We do not recommend discharge of conditions at this time. Following our previous correspondence one of our engineers has now visited the site and observed the in-situ drainage. Our inspection has confirmed the following:

Drawing Title
DRAINAGE LAYOUT - PLOTS 1-23 & 33-38
38 UNIT SITE - SHEET 1 OF 6

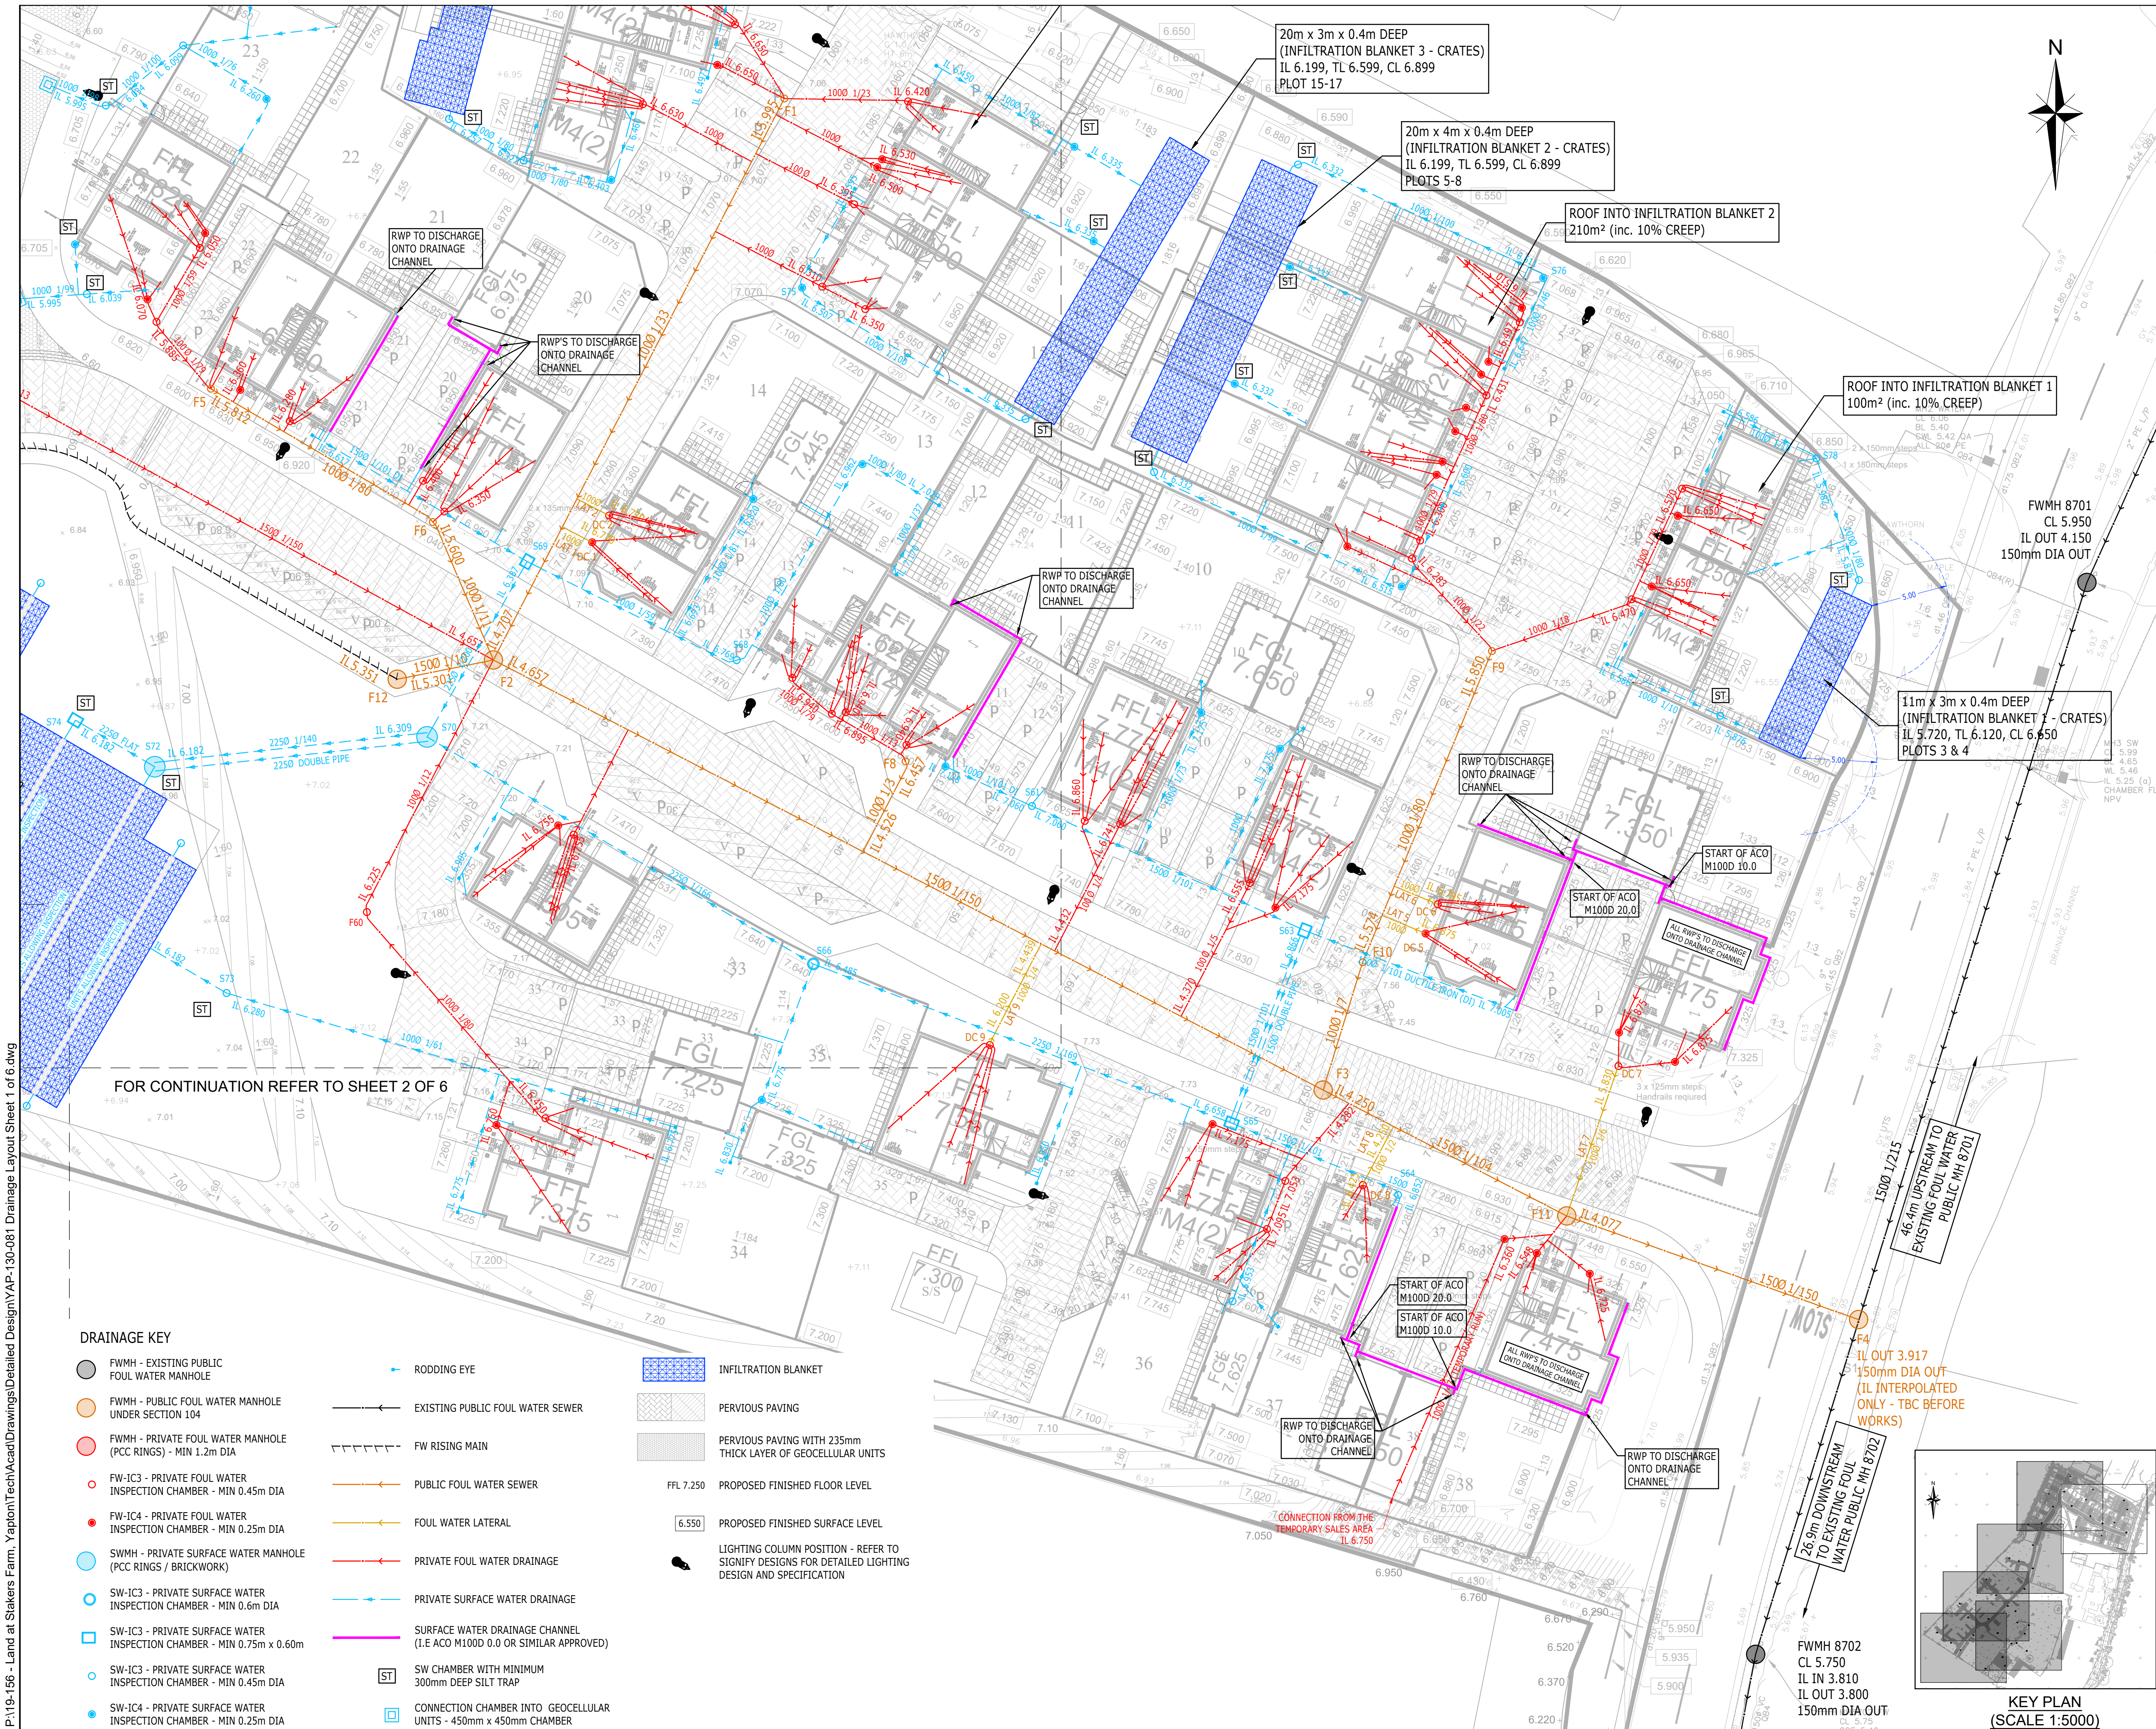
2. Manhole S72 (inlet to infiltration tank west of plot 33);
 - a) This manhole is specified as silt trap with 300mm sump. The silt trap that has been constructed is of an unconventional design and does not appear to be 300mm deep as originally designed. This silt trap will need remediation.

- b) The twin incoming pipes to MH S72 have been constructed as 150mm diameter pipes, as opposed to 225mm diameter. This will impact the capacity of the surface water drainage system to convey runoff. As Odyssey has not remodelled the pipework, it is possible this change could result in flooding of properties unless remediated or remodelled to confirm it does not cause flooding.

- c) The outlet from MH S72 is a single 150mm diameter pipe, Drawing Yap-130-082 shows this should have been two no. 225mm diameter outlets, connecting into the inspection channels (which are also not present). As Odyssey has not remodelled the pipework it is possible this change could result in flooding of properties unless remediated or remodelled to confirm it does not. We also have concerns about the impact this may have on siltation, and air locking of the soakaway during high flows, as there is no vent system in place.

4. Manhole S70 (west of plot 33);

- a) The outgoing pipes are twin 150mm diameter pipes as opposed to the original design (225mm diameter). As Odyssey has not remodelled the pipework, it is possible this change could result in flooding of properties unless remediated or remodelled to confirm it does not.

- b) The incoming pipe from the north is 150mm in diameter, as opposed to the design (225mm diameter). As Odyssey has not remodelled the pipework, it is possible this change could result in flooding of properties unless remediated or remodelled to confirm it does not.

5. Manhole S69 (adj. to plot 20);
- a) A 150mm diameter outlet has been installed, as opposed to the design (225mm diameter pipe). As Odyssey has not remodelled the pipework, it is possible this change could result in flooding of properties unless remediated or remodelled to confirm it does not.

- b) A 100mm diameter inlet has been installed (incoming from west) as opposed to the 150mm diameter proposed. As Odyssey has not remodelled the pipework, it is possible this change could result in flooding of properties unless remediated or remodelled to confirm it does not.

6. Manhole S73 is located in a different location to that shown on the design plans. A survey of this manhole will need to be carried out.
7. Manhole S65 (adjacent to plot 36);

- a) This manhole is located within the permeable paving, as opposed to the location shown on the plans. If it is to remain in this location, confirmation that the volume of storage within the paving lost to this manhole will be required.
